Drawing Title
Indicative Construction Access and Compounds
Sheet 2 of 5

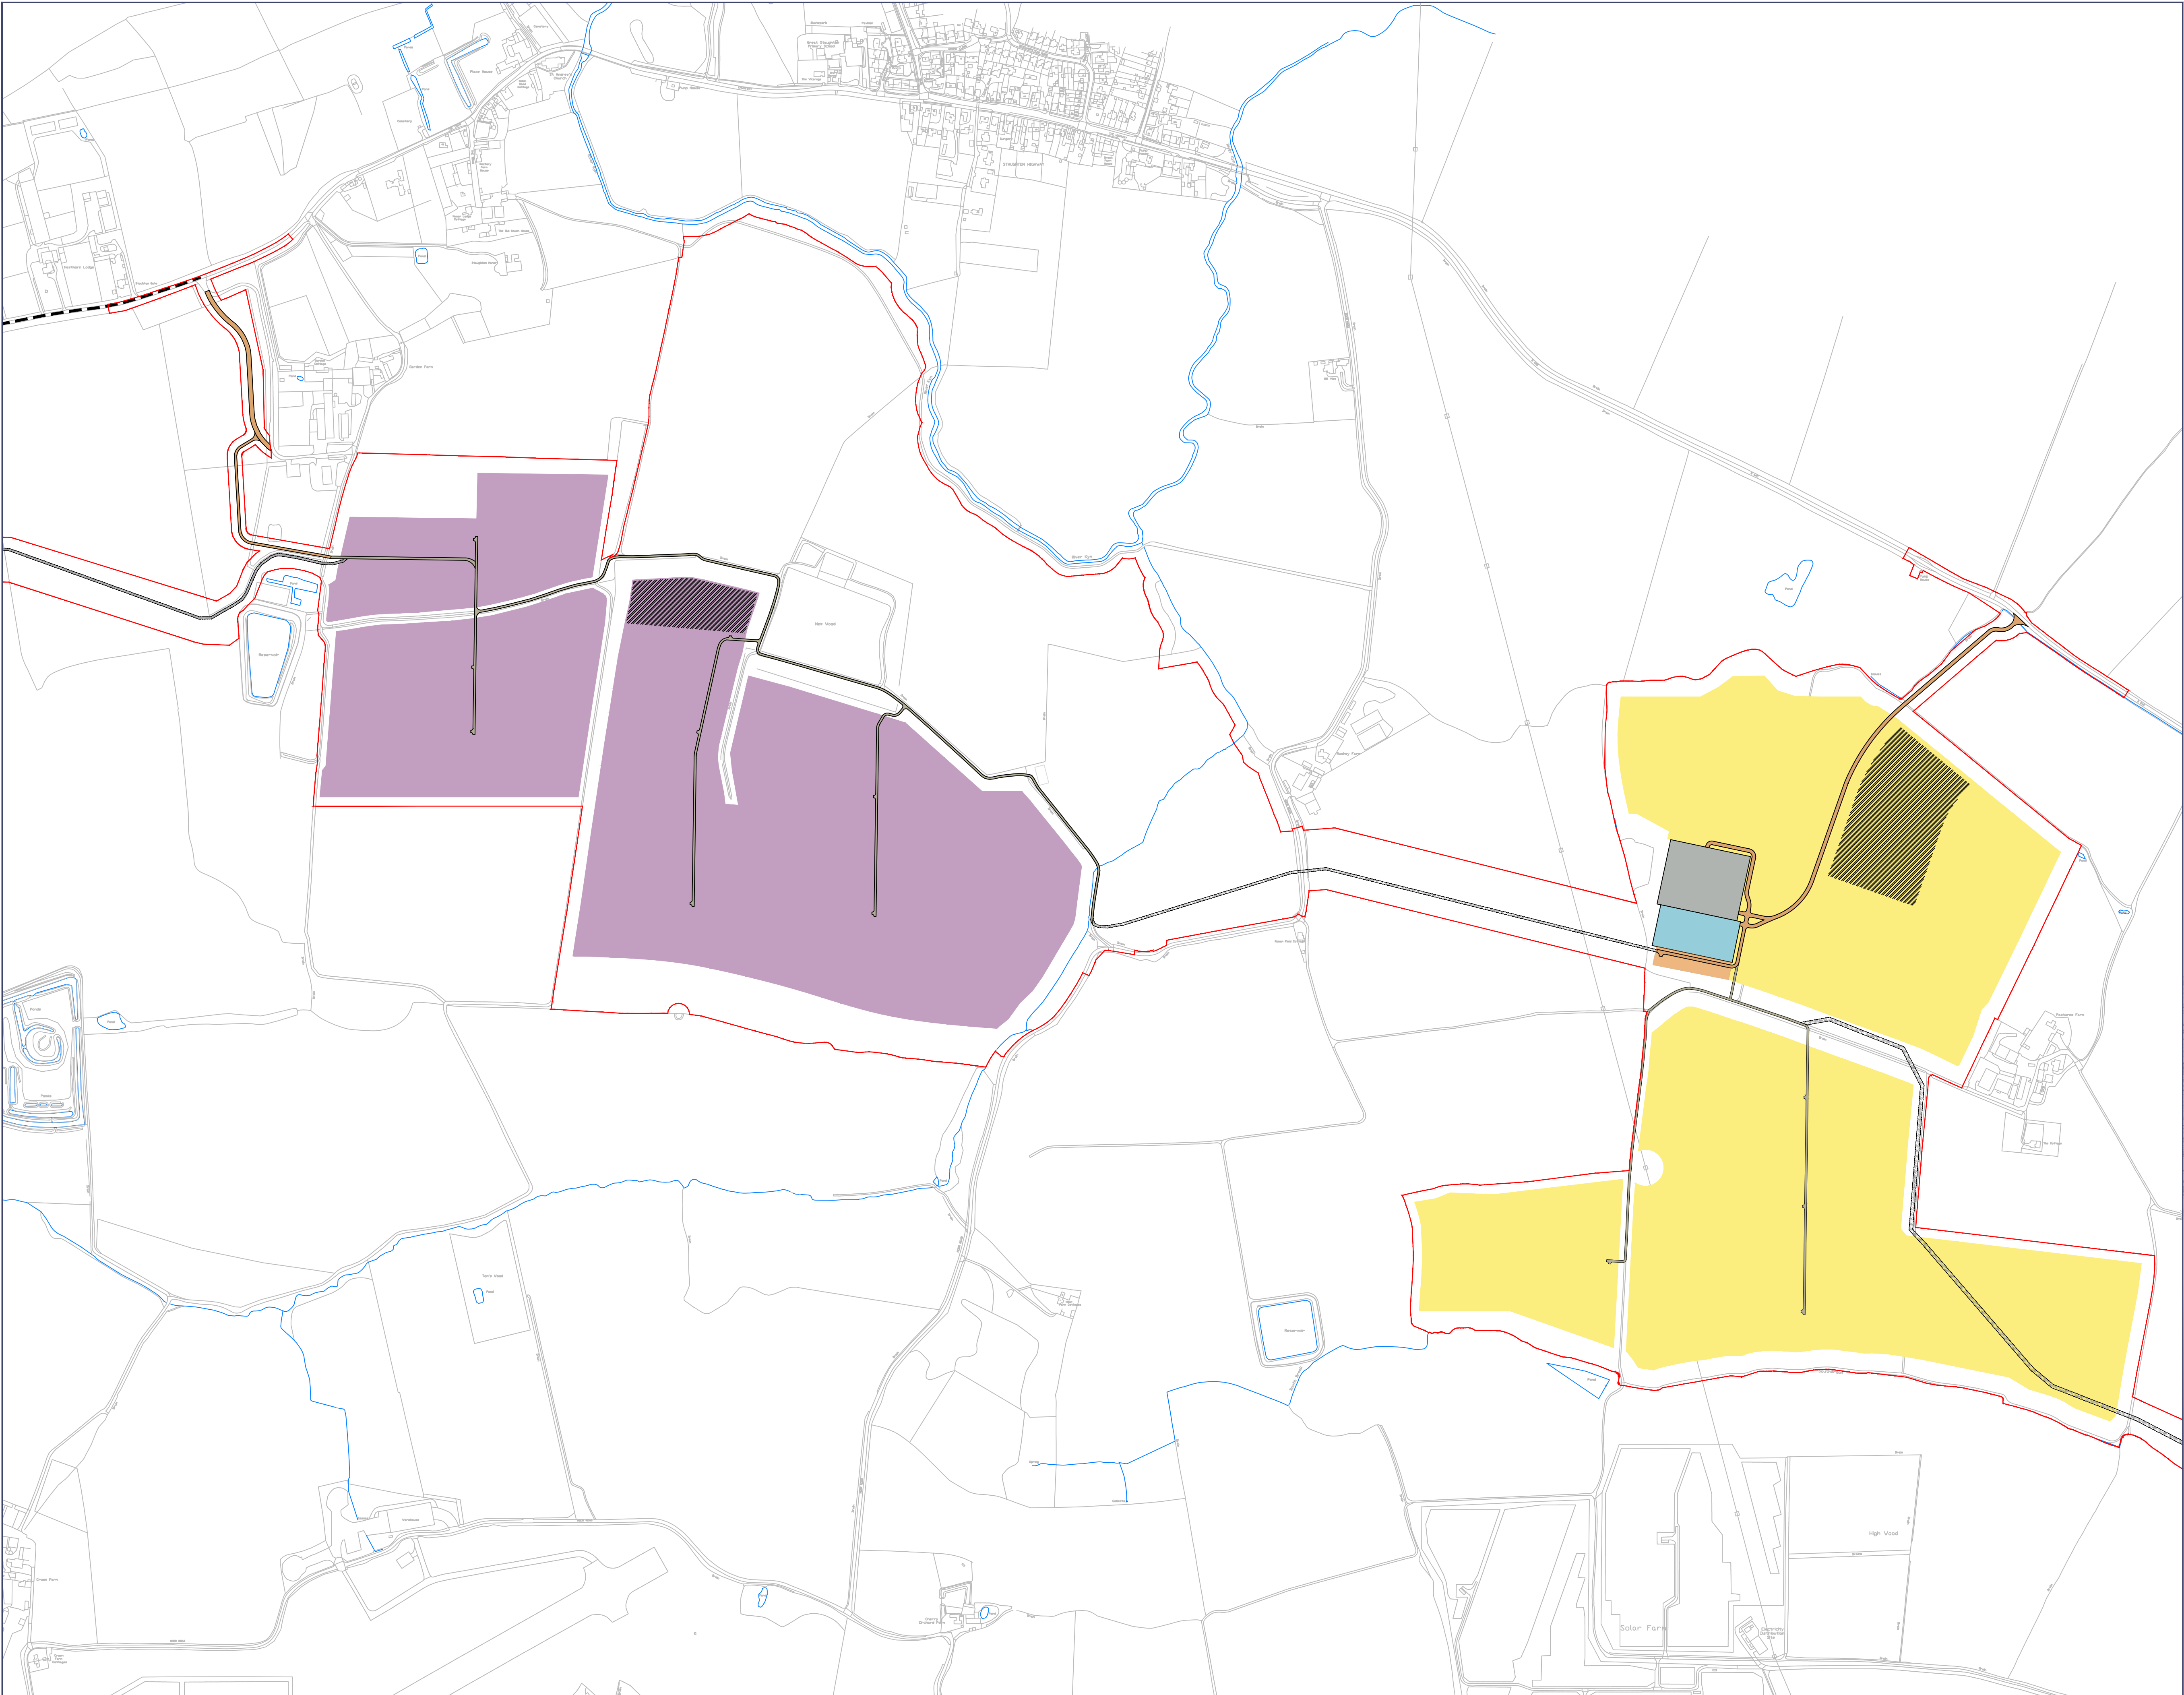
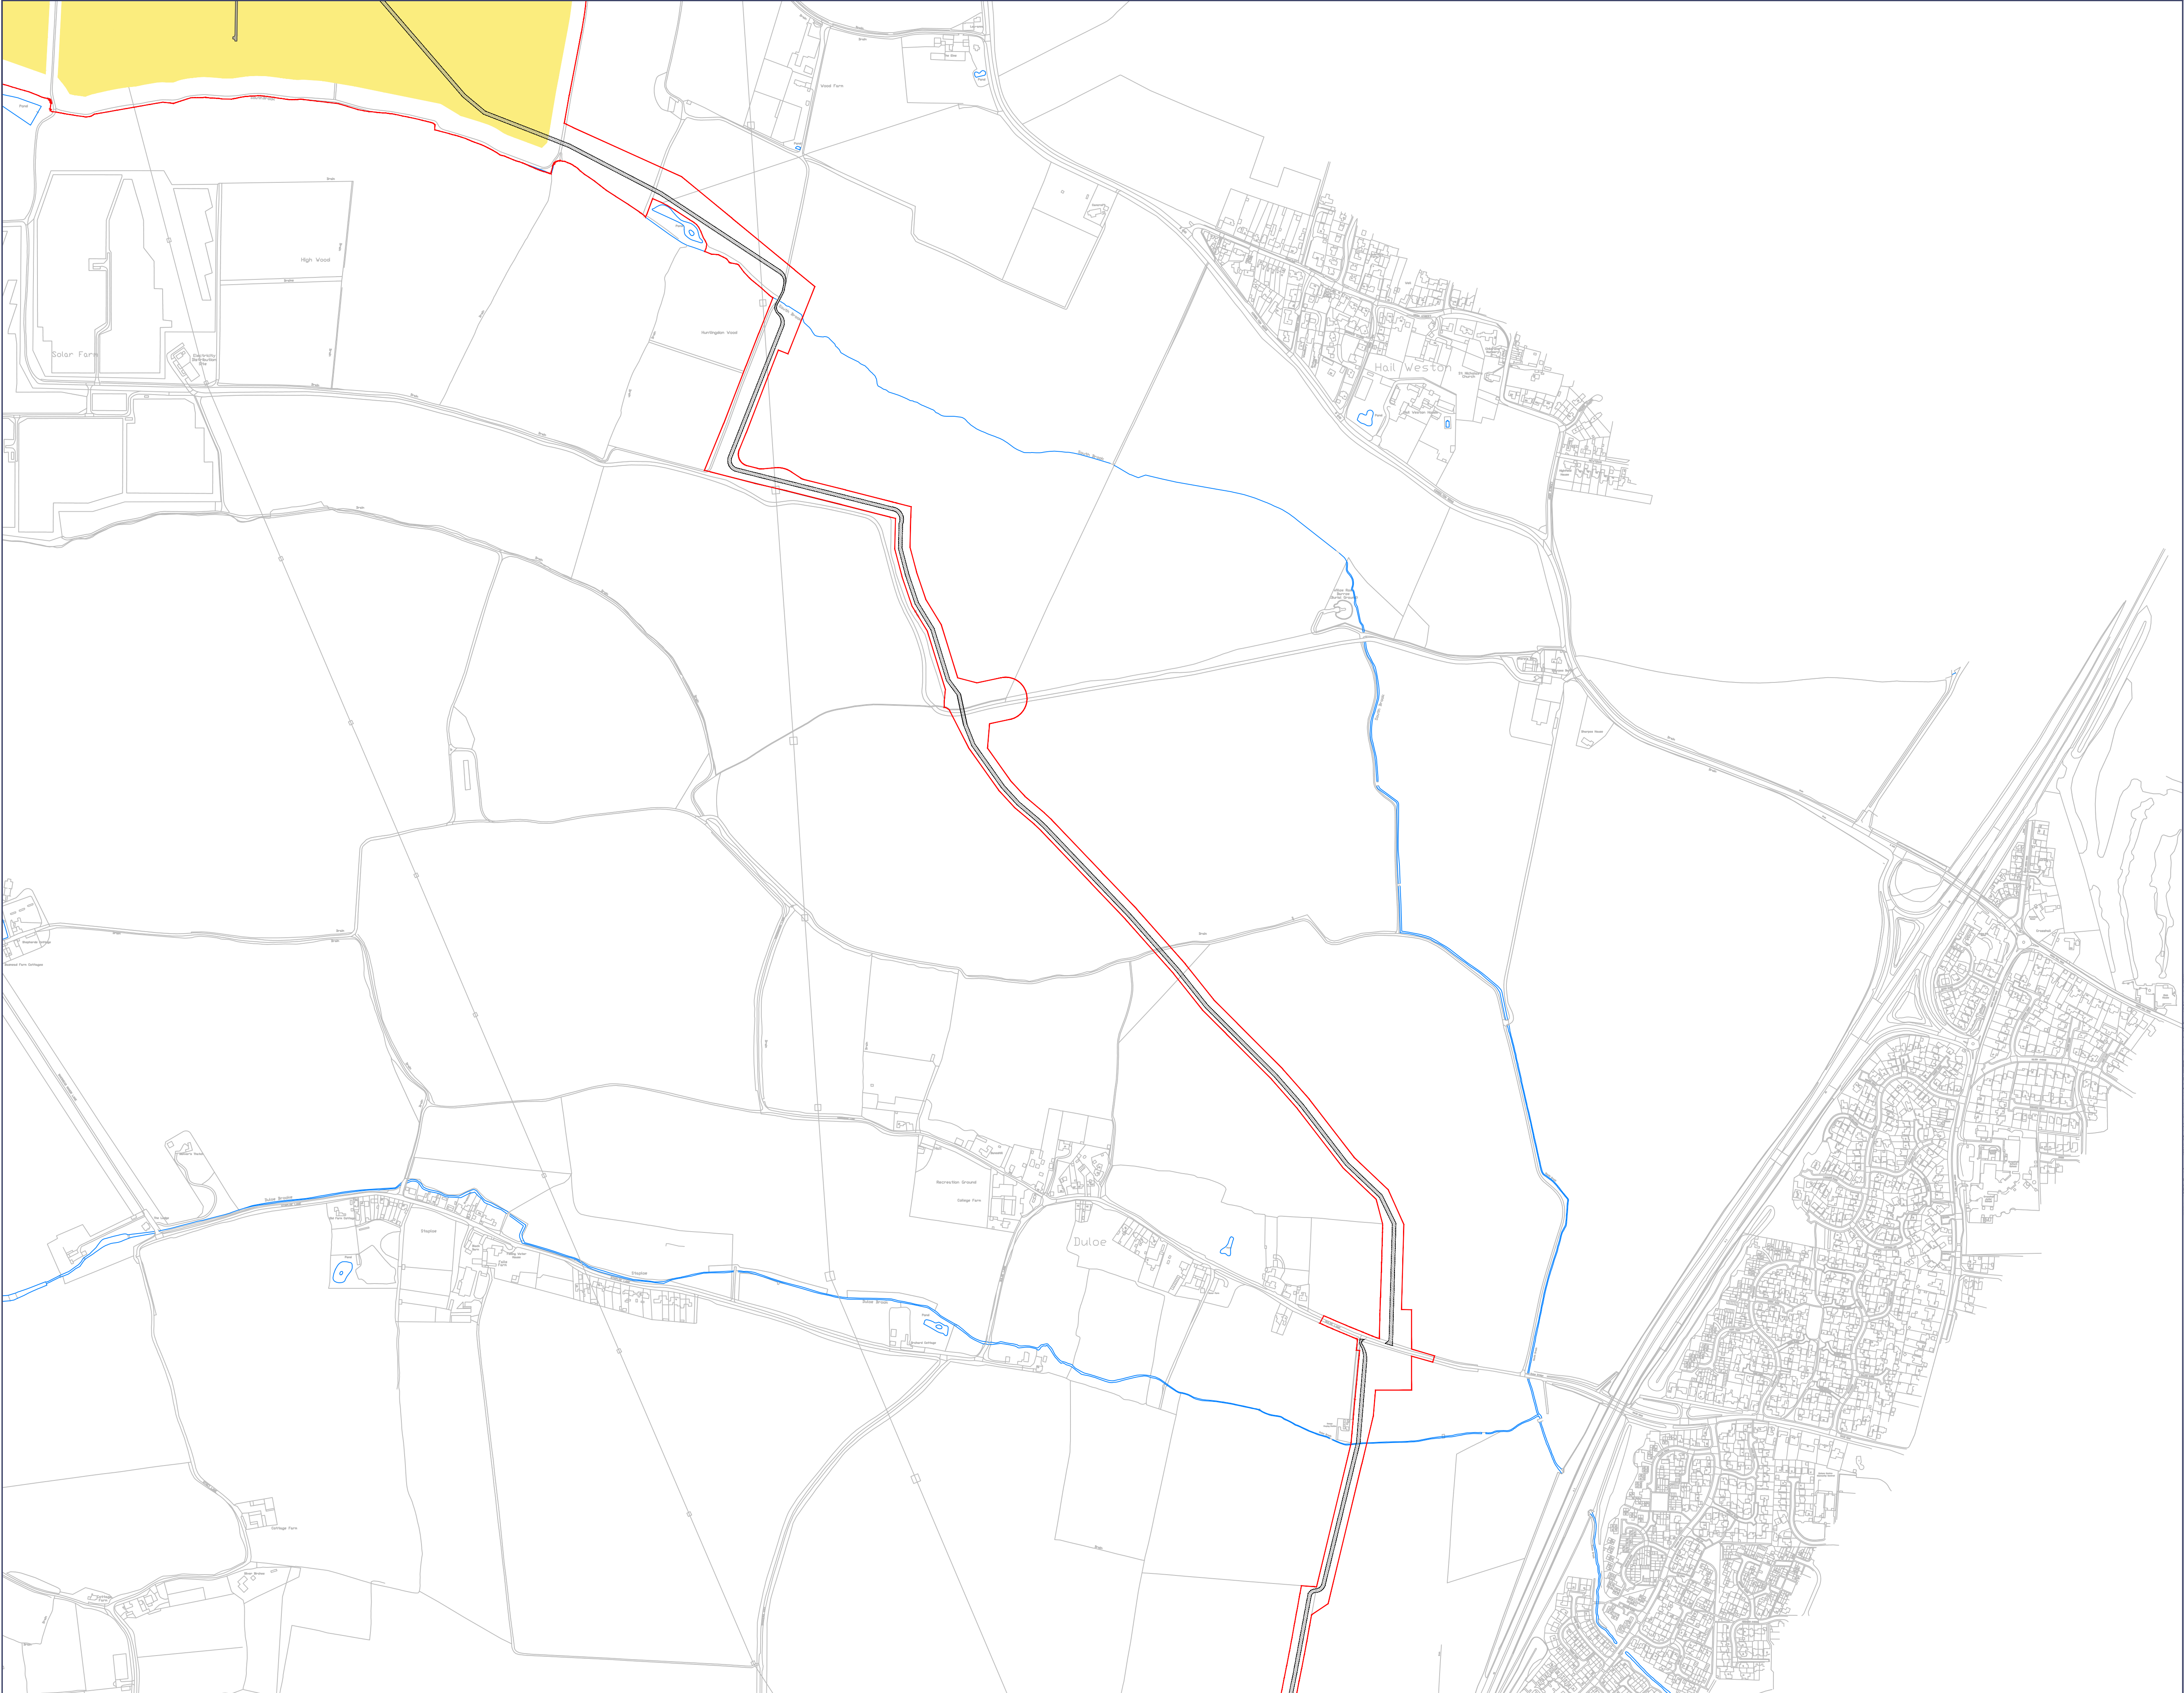
1. High Wood Solar Farm; this is in fact on a very busy B645 on a sharp bend so high volumes of traffic will be extremely dangerous and the path opposite is the only walking route for residents of Hail Weston.

2. Section 2 - Santra access (SA12) Spring Hill to Green End. This road is very narrow with tight blind bends.
3. SA06 access from Green End. This is already a dangerous crossroads at Kangeroo and has cars, bikes, motorbikes, horses and runners going through the junction regularly. The road from Kangeroo to the B645 is already showing as 'unsuitable for heavy vehicles' and two cars are not able to pass each other without slowing right down. Horse lorries have already been stopped from using this road. The plan is for the junction to be used for SA03, SA04, SA05 and SA06. This is a major accident hazard and the narrow roads would mean emergency vehicles could not get through.

4. Green End to Little Staughton. SA08, SA07, SA09 are all by homes. Green End goes through part of the village of Great Staughton next to homes.
5. It is unclear on Section 3 where the traffic is planned. It says turning right but if it is a right turn, how is the traffic getting to Manor Farm.

6. Section 4 Moor Road. This is a very narrow road with dangerous blind bends and is totally unsuitable for the volume of heavy goods vehicles planned.
